**20221027-ABP-314232**

**Ref: 314232**  
**App: Córas Iompair Éireann**  
**For: DART+ West Railway Order - Dublin City to Maynooth and M3 Parkway Railway Order Application**

STRUCTURE DESIGN
OBG14. BRIDGE DECK RECONSTRUCTION
FINAL STATE

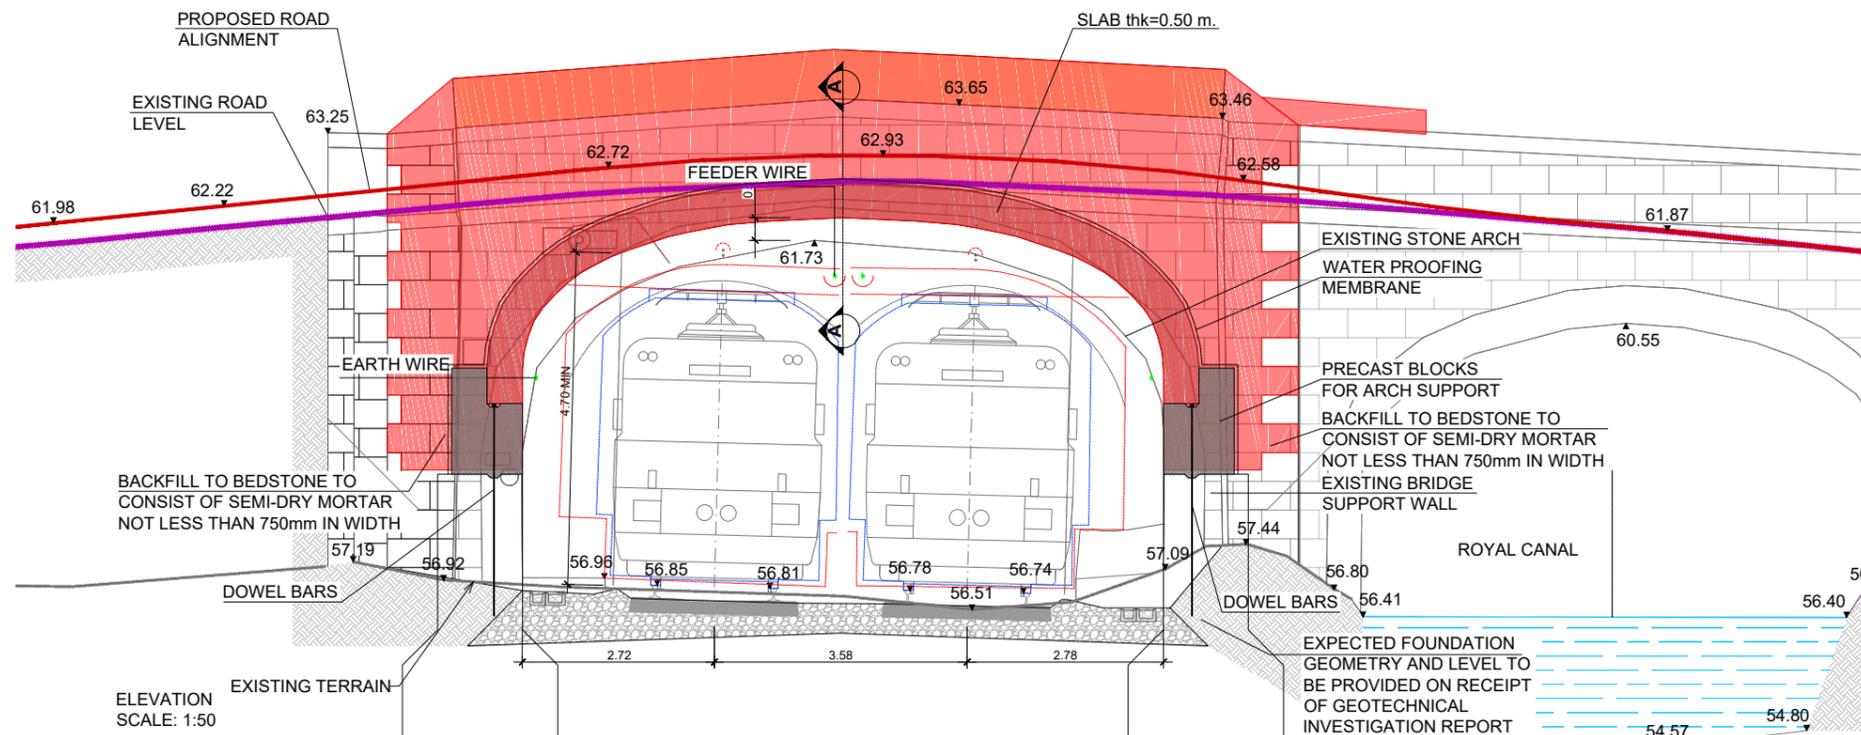
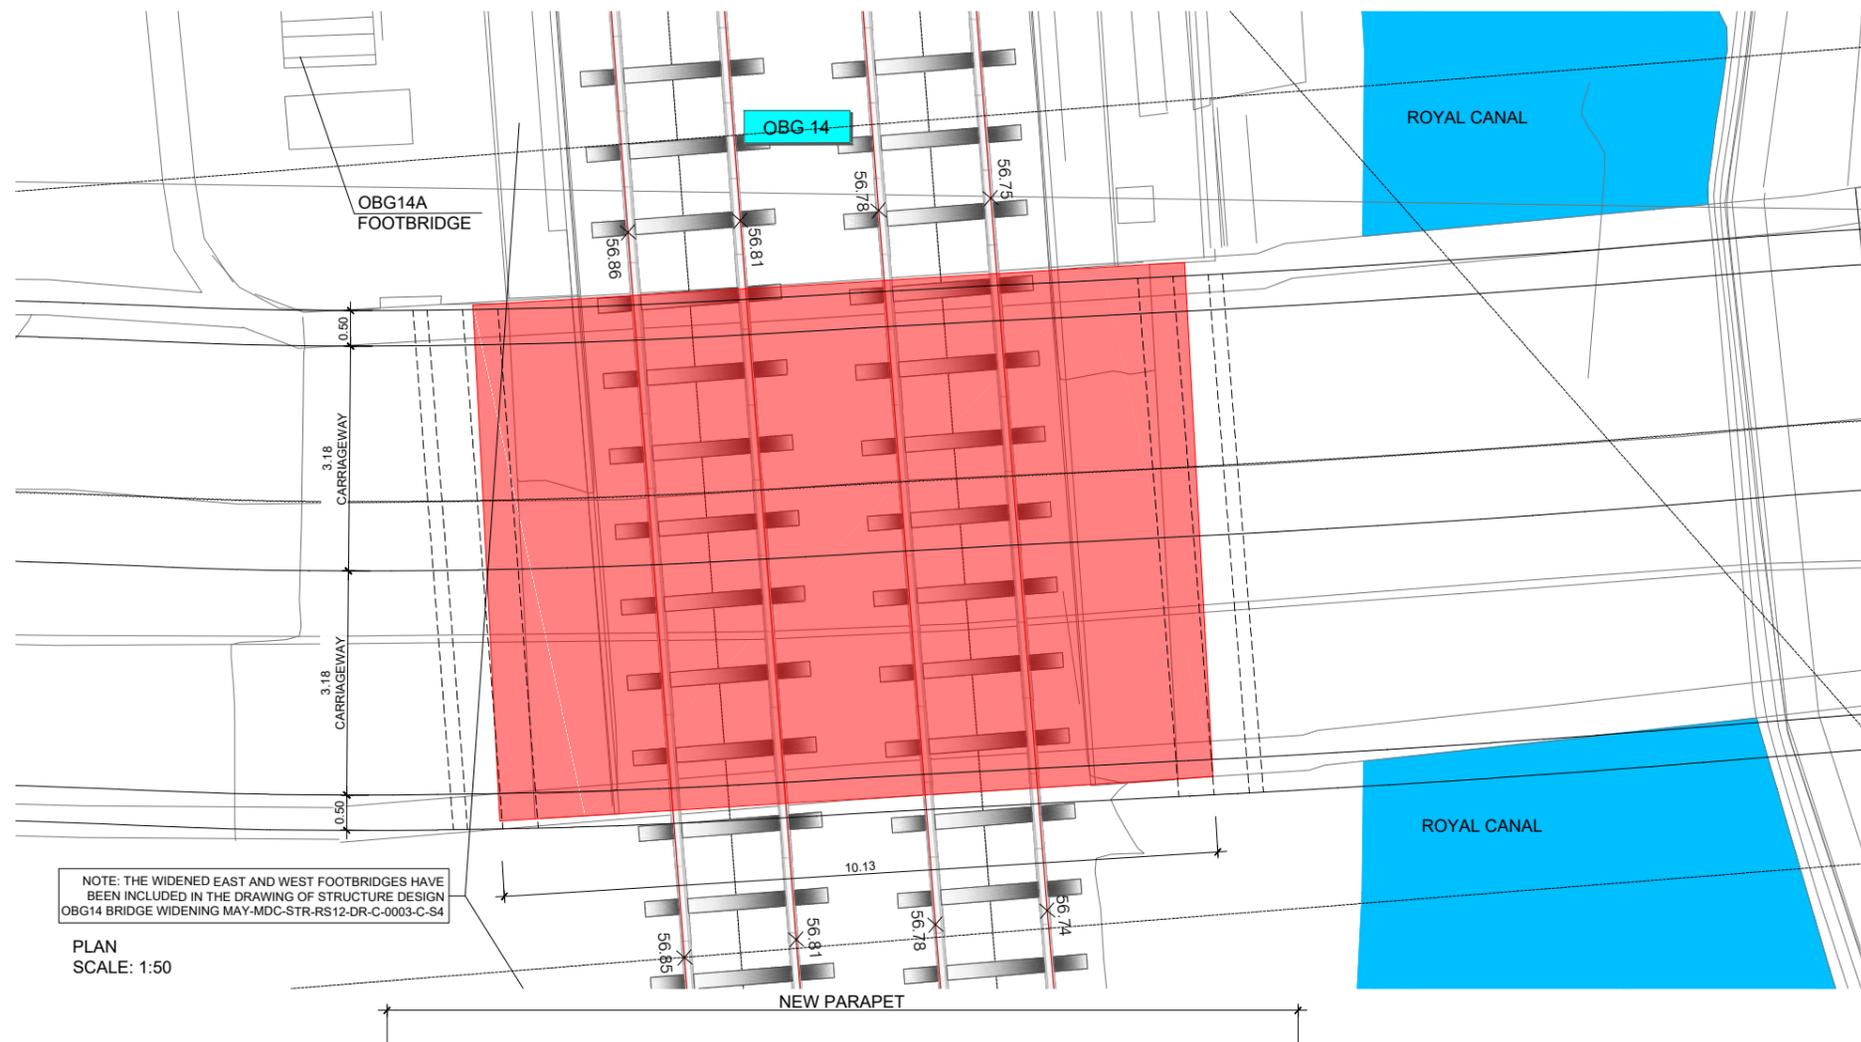
### Leixlip Confey Station Rail Bridge - Demolition and rebuilding.

As a better alternative than to demolish and rebuild this historic structure from 1845, to achieve an extra height of only 30cm, we recommend that the combination of track lowering be followed, and the installation of a reduced height overhead line equipment (OHLE) for the reasons explained in the previous entry under Broombridge, be adopted.
